## **Parish Council Response to the Bicester Motion Automotive Experience planning application 21/01224/OUT**

Stratton Audley Parish Council has reviewed the application for the Experience Centre and is generally supportive of the plans put forward. Although the application is for Outline planning permission, it is clear that much time and effort has gone into the thinking behind the plans and if they are developed as envisaged, it will help to ensure the continued viability of Bicester Motion as a major centre of leisure facilities as well as technical expertise in the automotive sector. It is in this spirit of support and cooperation that we would like the following concerns to be given serious consideration.

Figure 3.5: Local PRowS

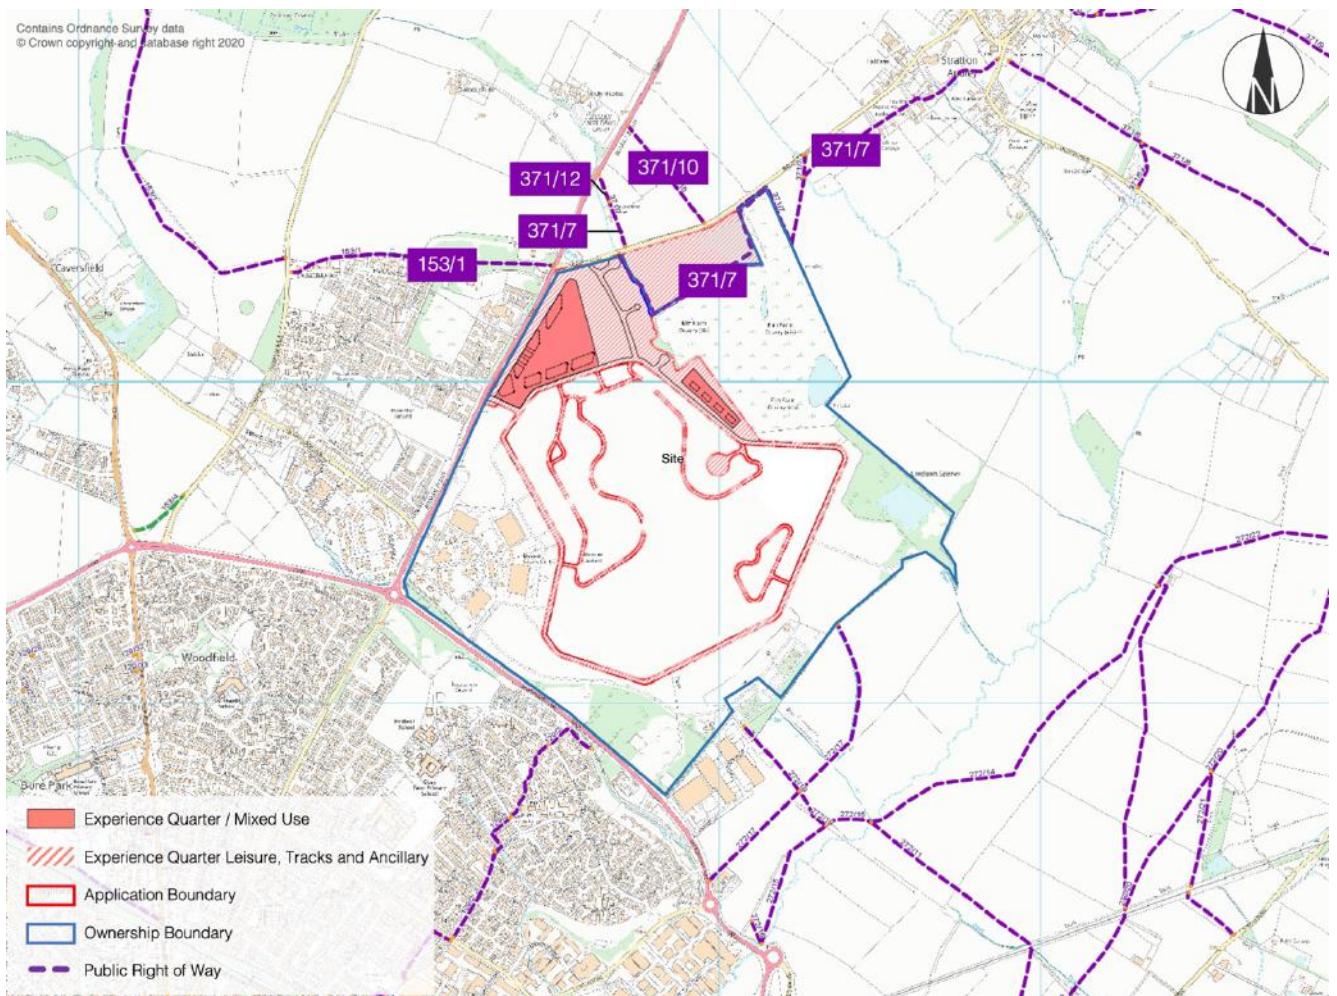
- There is also a public footpath that runs through part of the proposed development from the direction of the village and we understand provision to re-route this will form part of future plans when the Wilderness area is

developed. However we do not think this is acceptable and ask for this to be rightly built into this current application;

- The most logical route for this will be to re-route the ROW and run it parallel to the Bicester Road behind the hedge row and between the proposed 4x4 track, up against the perimeter fence. We maintain that it should be made into a shared use path and extend up to the secondary service access entrance at the top of Bicester Road.

Figure 3.4.1 Aerodrome Circuit Patterns with Noise Sensitive Areas Highlighted.

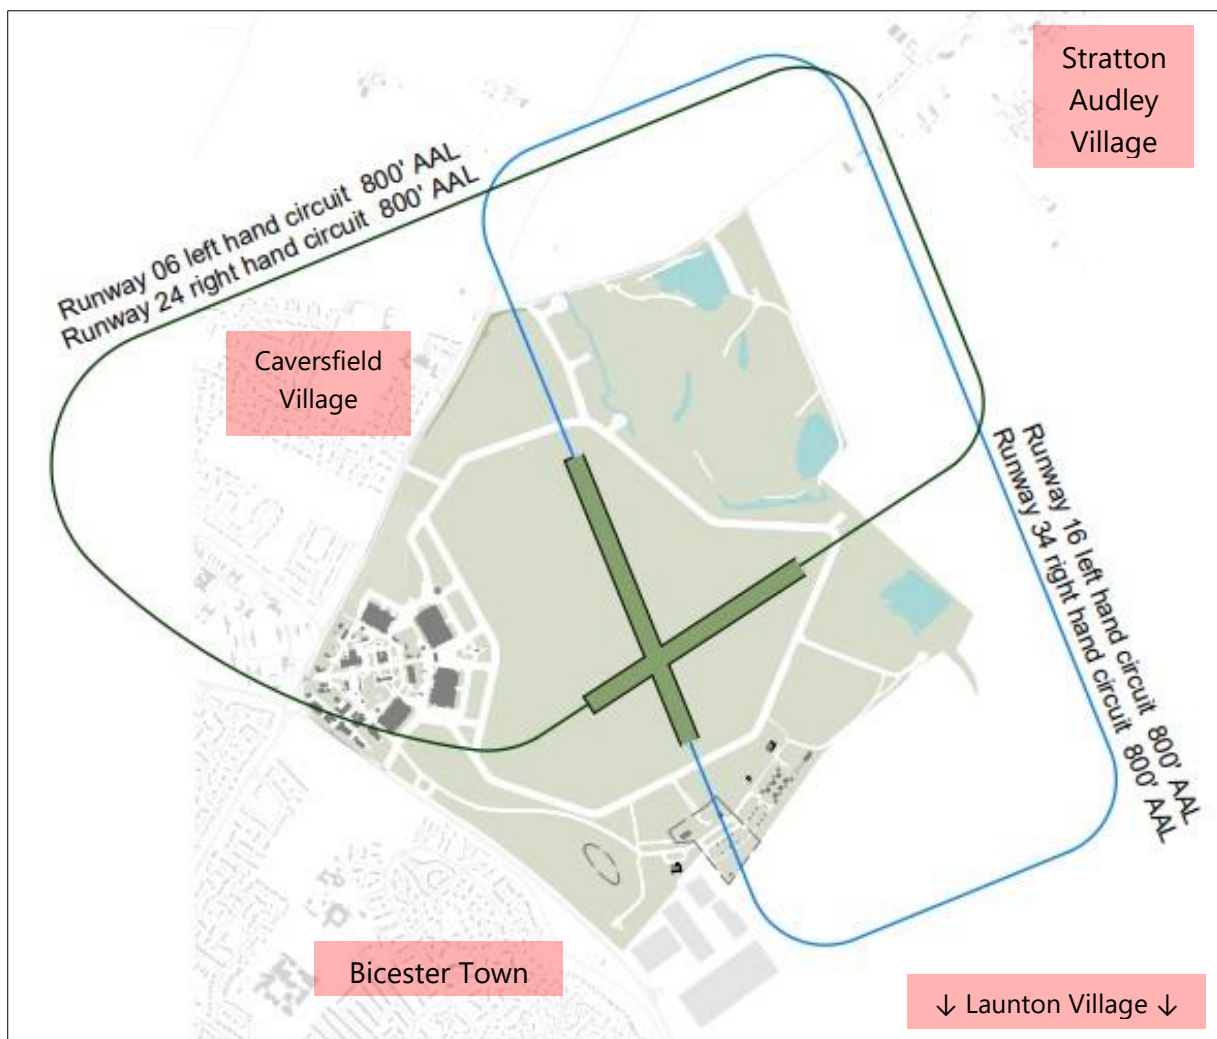
- We would like clarification on aircraft circuit patterns in the skies over and around the village as there have been some infringements in the past which have been unacceptable;

- We also seek reassurance that the re-configuration of the landing and take-off field into two strips of grass runway, will not result in aircraft being directed over the village in such a pattern that does not exist at the moment.

job title: Bicester Motion  
 Brand Experience Application  
 drawing title: Proposed Access

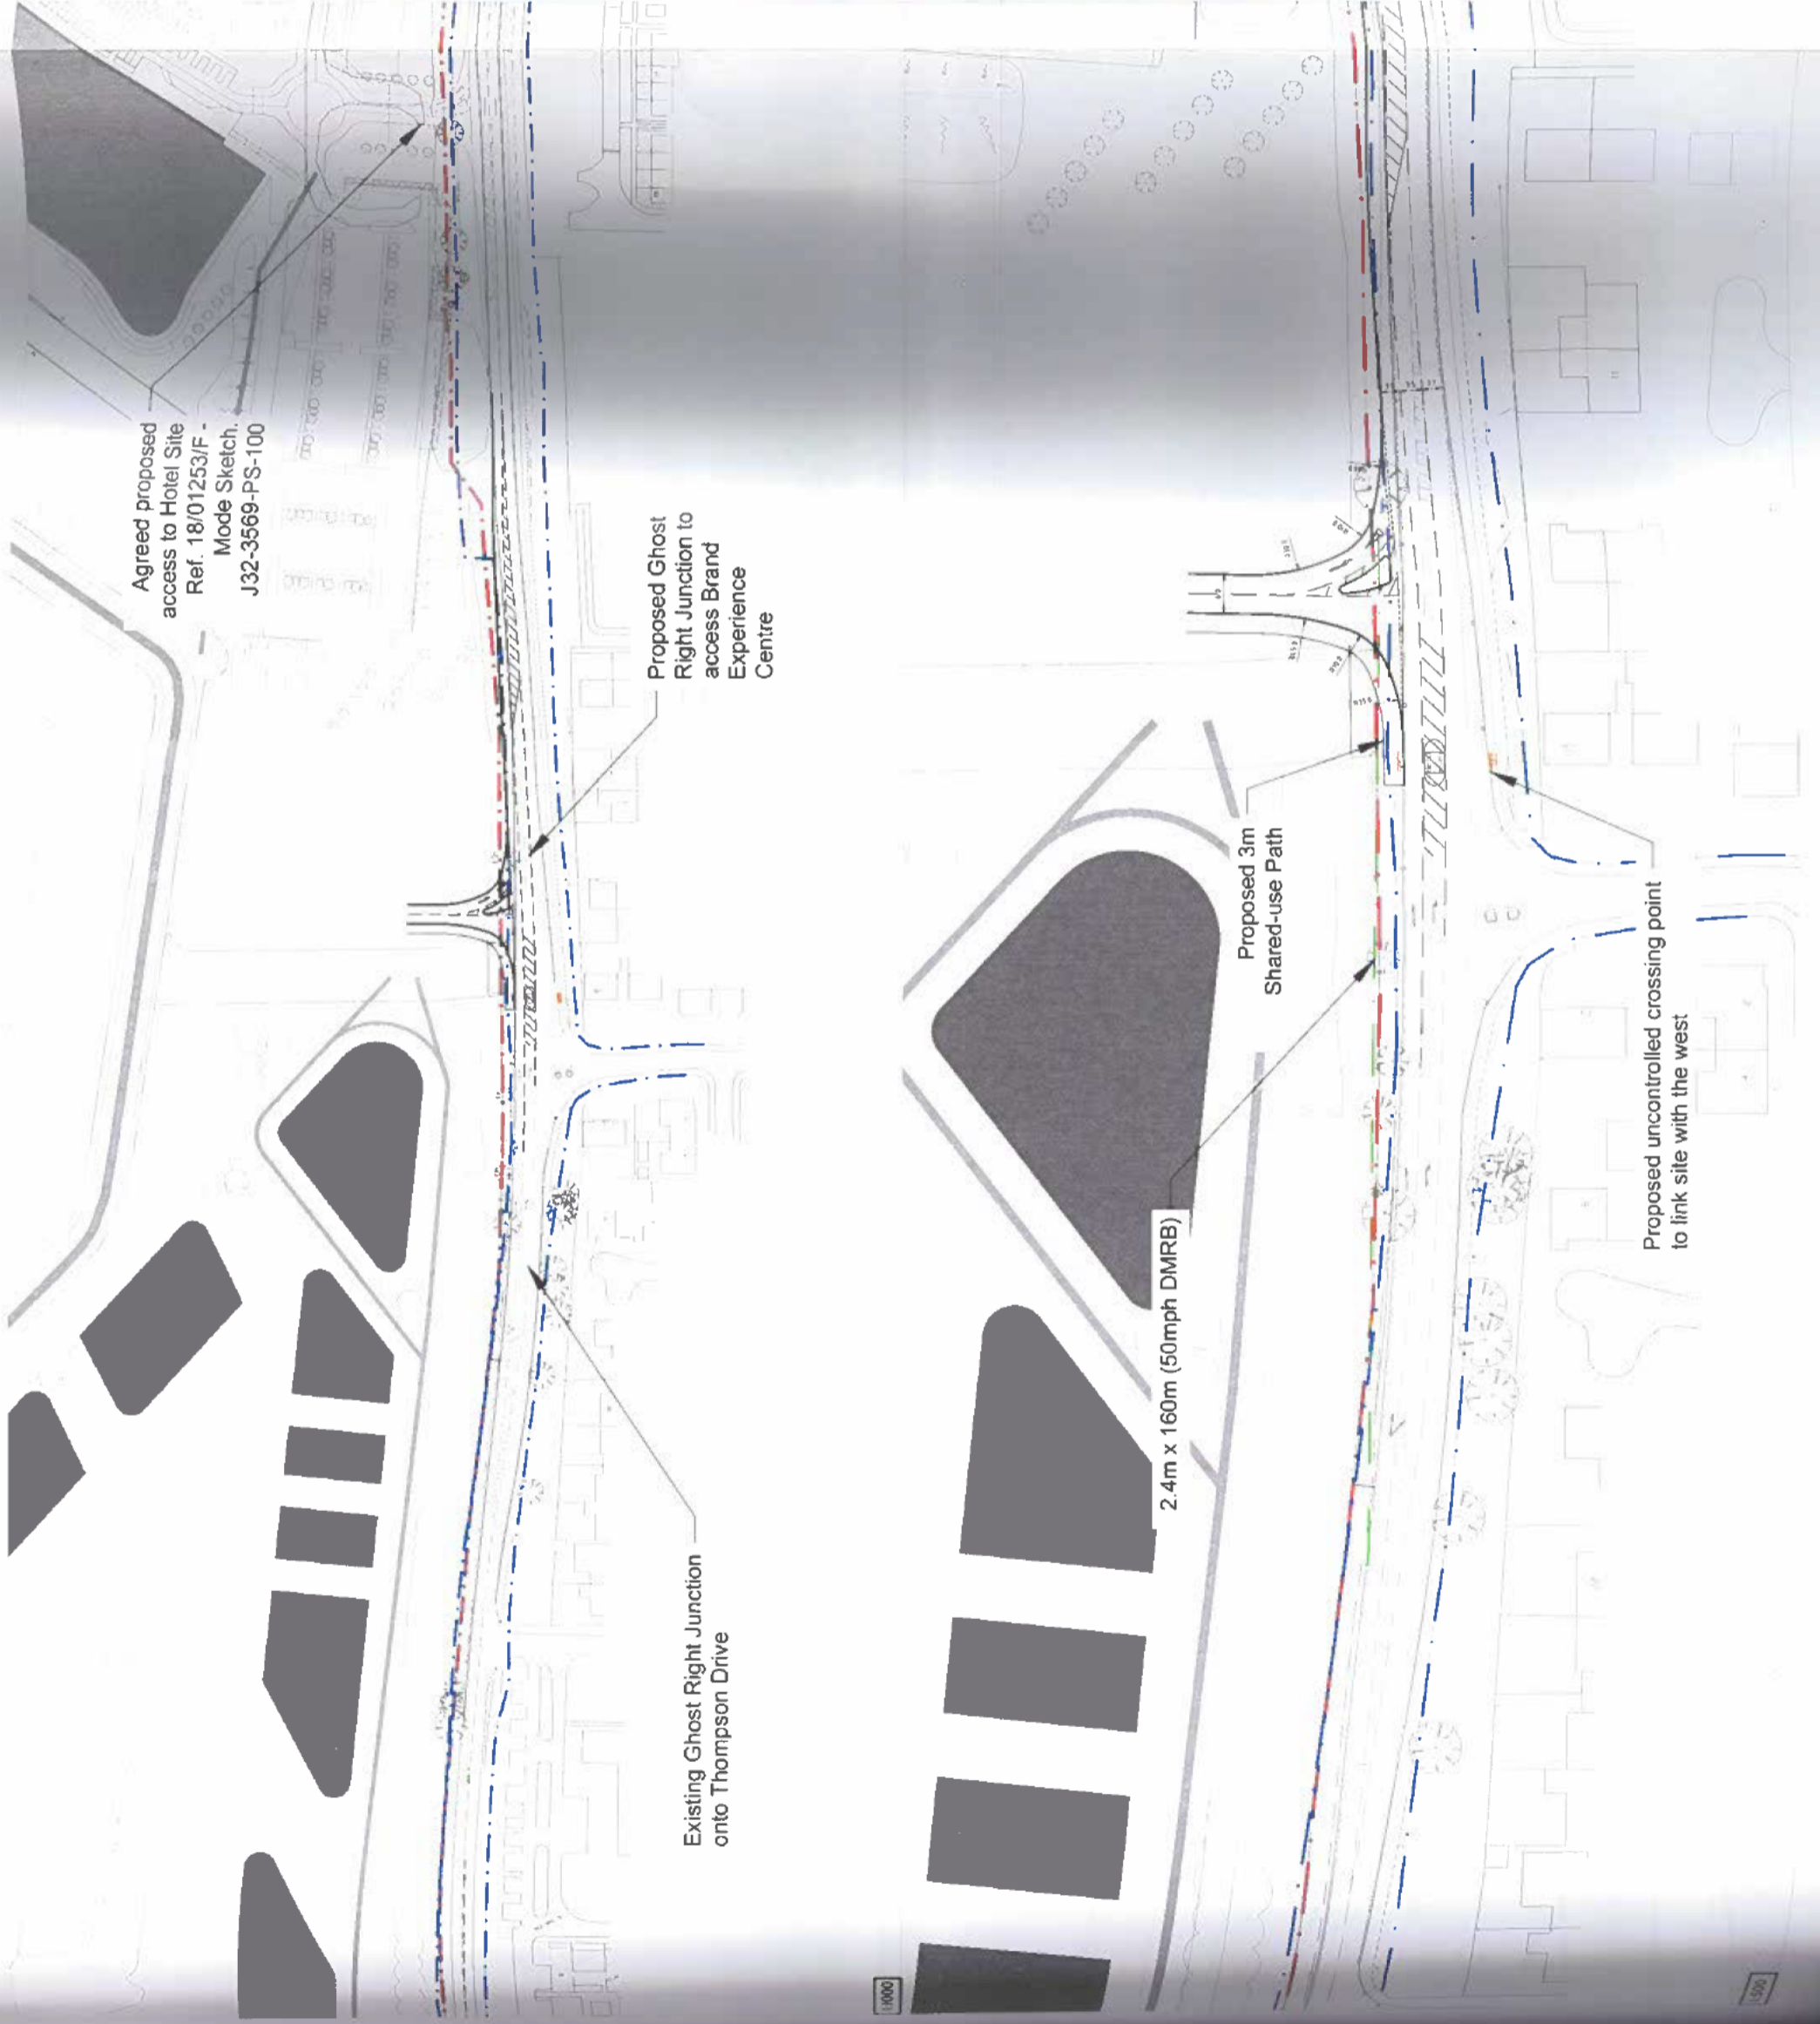
- The A4421 at this particular point where it intersects with the junction with the Bicester road leading to Stratton Audley is already a dangerous pinch point, so with increased traffic especially large delivery vehicles using the secondary service entrance in the Bicester Road, it will quickly turn into a black spot. We accept that there are no significant Highway statistics to support this in terms of accidents, but this is because local people who ride bikes or like to walk, tend to avoid this part of the road;

- We believe that the A4421 over a short 300 yard section leading up to the junction with Bicester Road needs widening and a right hand filter included and would ask OCC Highways to insist upon improvements to this stretch of road as a priority measure;

- We seek assurances that all work to the road infrastructure is carried out and completed in advance of the commencement of works within the site, since both the A4421 and the Bicester Road will become more dangerous in the building phase (with construction traffic and service vehicles) prior to any congestion caused by increased numbers of visitors;
- In order to establish current vehicle movements, we ask that a traffic volume measure test is set up on the Bicester Road. This data can be compared to data captured in 2014/15 when traffic volumes were last measured on the same road. This we believe will demonstrate to what extent volumes have increase in a five year period;
- We also believe that traffic calming measures must be introduced such as a lowering of the speed limit to at least 40mph on A4421 from the main roundabout up to the Stratton Audley turning.
